# CITY OF ALBUQUERQUE

April 12, 2019

**Re: Fiesta Kia Group,  
7400 Lomas Blvd NE, 87110  
30-Day Temporary Certificate of Occupancy  
Transportation Development Final Inspection  
Engineer's/Architect's Stamp dated 6-13-18 (K19D152)  
Certification dated 4-5-19**

1 SITE & TRAFFIC CIRCULATION PLAN
Scale: 1" = 20'

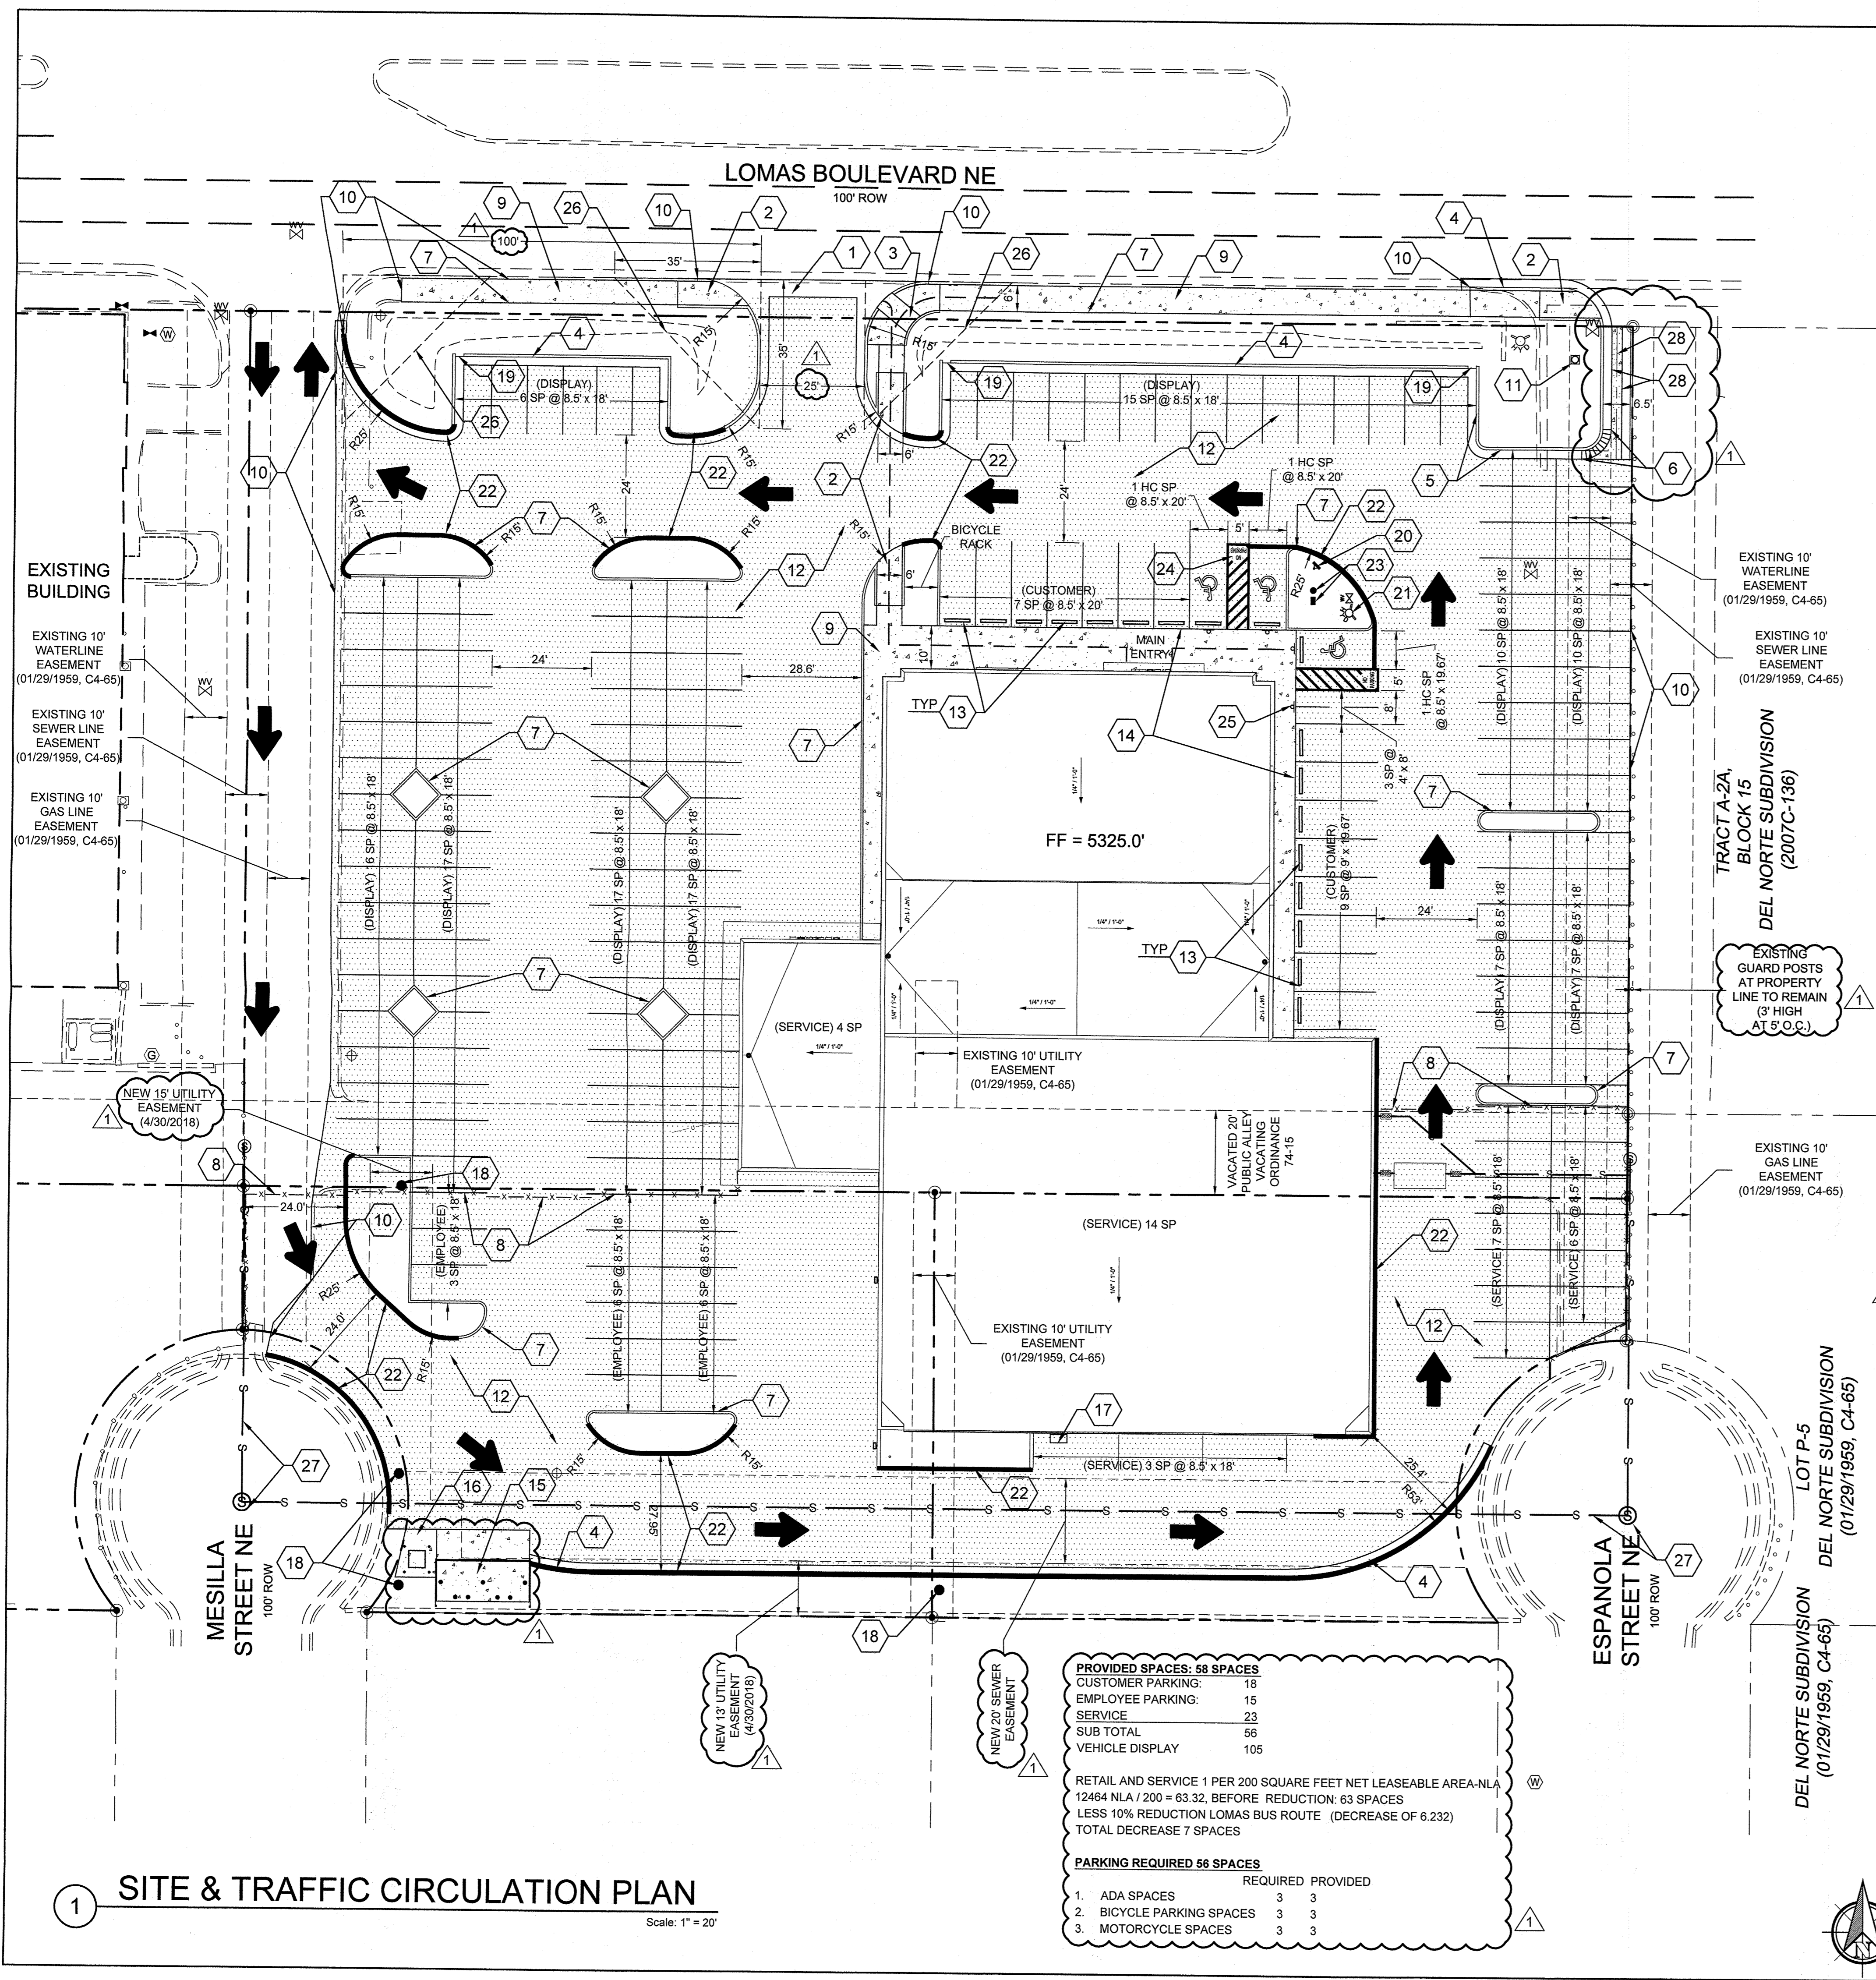
1. Please add Motorcycle Sign to the relocated 3<sup>rd</sup> MC Stall.
2. Please send photo of correction for final CO.
